Our ref: D3.25.0356

App no: 25.0356

Address: 4 - 5 Brookside Holden Lane Bolton by Bowland

Proposal: Removal of three single storey extensions, erection of a single storey front entrance extension, rear two storey extension and fenestration amendments. Retrospective submission relating to the formation of front parking area.

Drawing Title
Proposed Site Plan
And Retaining Wall Elevations

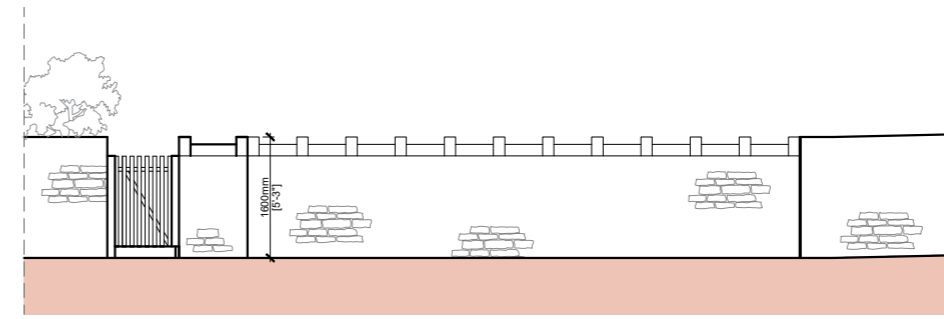
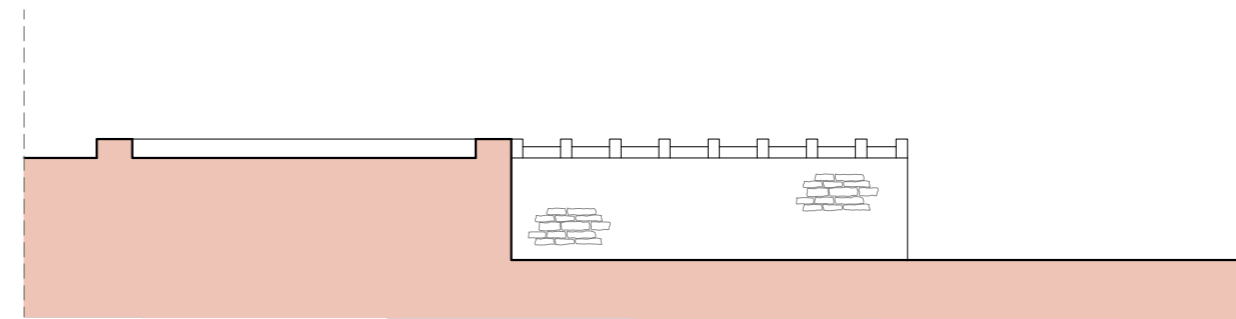
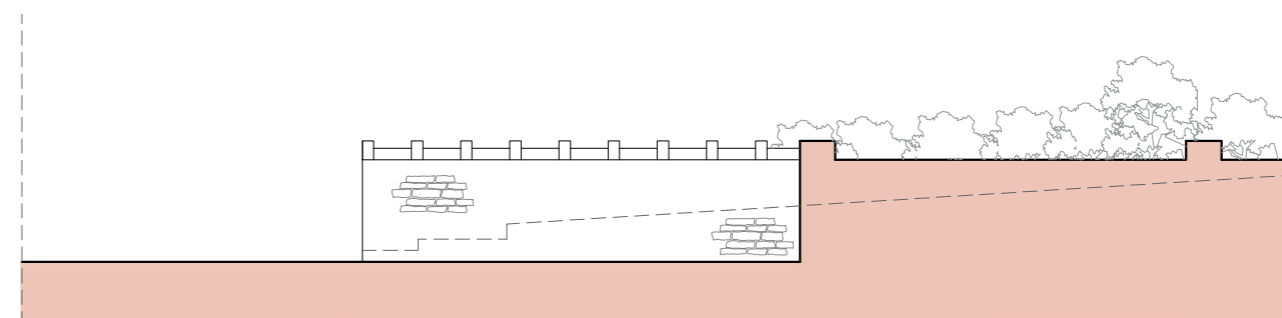
The parking area measures 7.25m wide by 5.79 tapering to 5.35m deep. The size is suitable to accommodate 2 vehicles.

The parking area is excavated into the land and is bounded by retaining walls.

1. The height of the retaining walls between the carriageway for at least 2m back into the parking area should be a maximum height of 1m. This is to allow the driver and highway users to maximise the visibility when manoeuvring at the access.
2. The surface of the parking area should be paved in a bound and porous material to avoid any loose material and surface water being deposited onto the highway and vice versa.
